Dear Ms. McGuire:

I'm writing to provide additional input on Mercer Island Permit Application 2207-019's recent [submission response memo](#) (SUB2) and corresponding revised [plans](#). On October 25, 2022, I and my attorney, Zach Davison, submitted comments during the public comment period on the initial plan set. This letter supplements those comments in response to the revised plans submitted by the applicant on March 1, 2023.

BASEMENT FLOOR PLAN

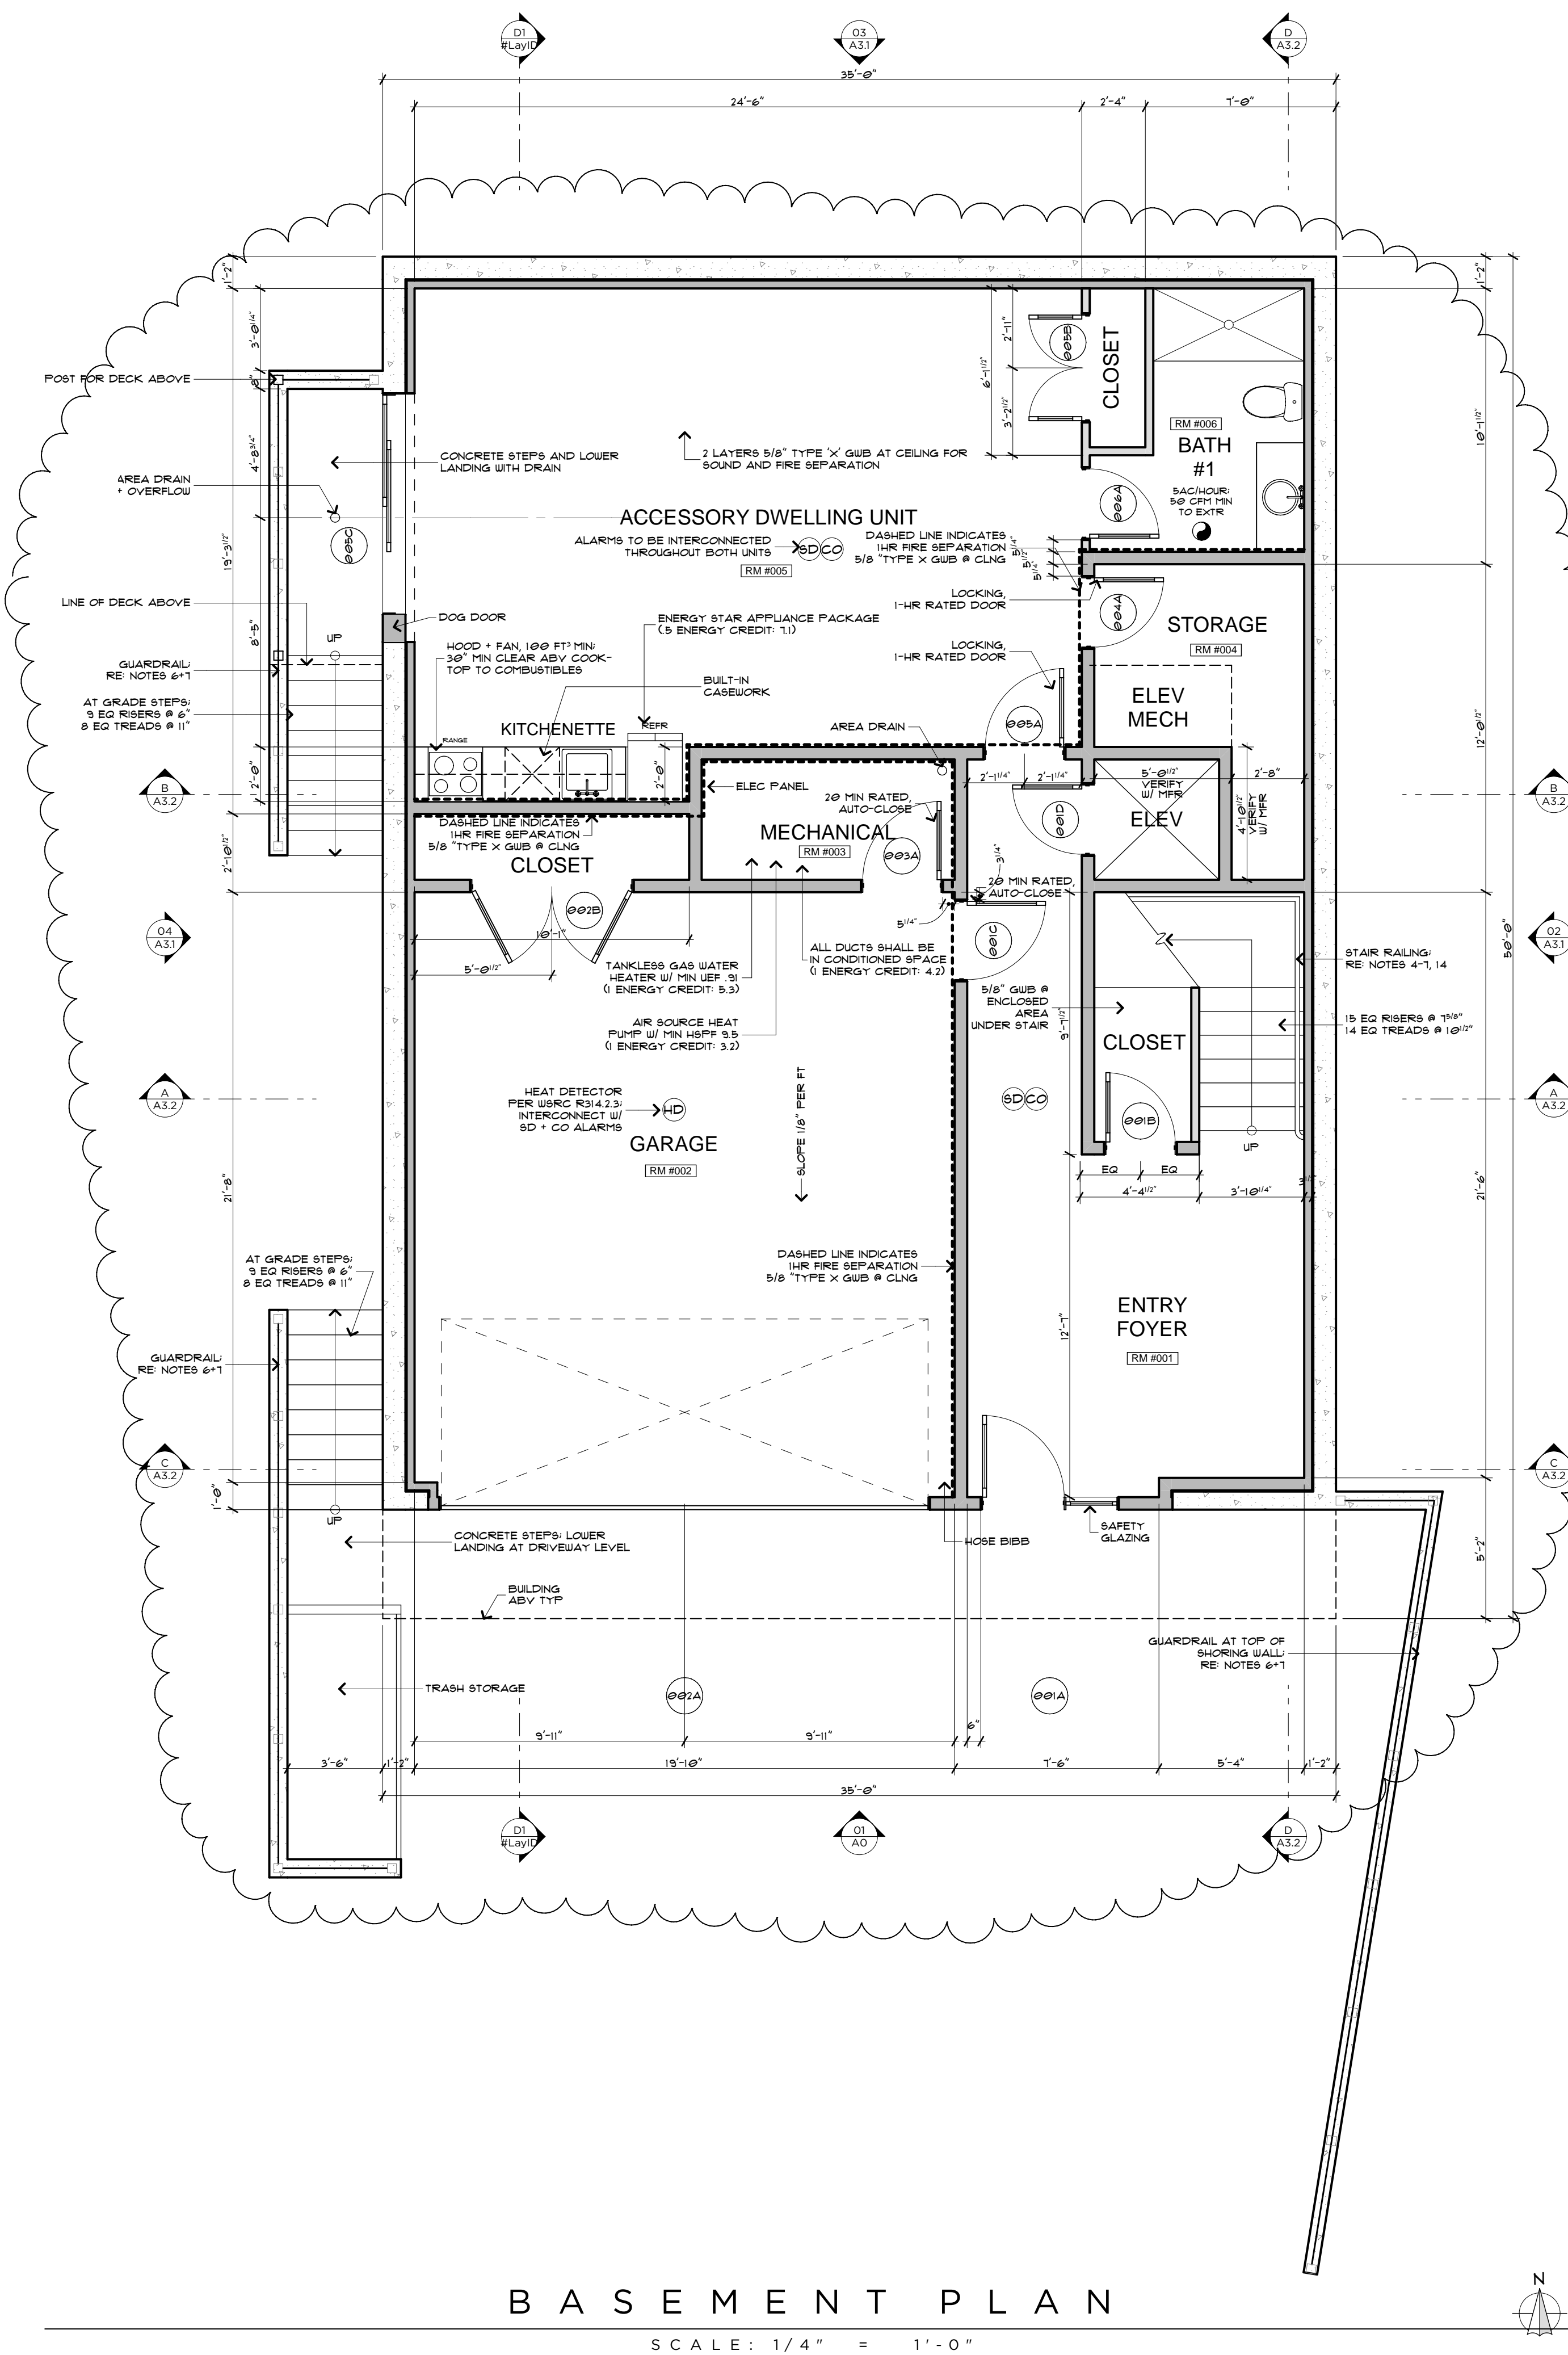
As a result of these errors, the Basement Exclusion is incorrectly computed. The incorrect Basement Exclusion contributes to errors in the GFA.

The proposed ADU is approximately 600 square feet, with claimed coverage of the basement is 58.2% (as a result, the ADU is only using net ~250 square feet [$\sim 600 * (1 - .582)$] in the design). An accessory dwelling unit may not be used to increase the GFA of the remainder of the proposal (MICC 19.2.020.D.3.b).
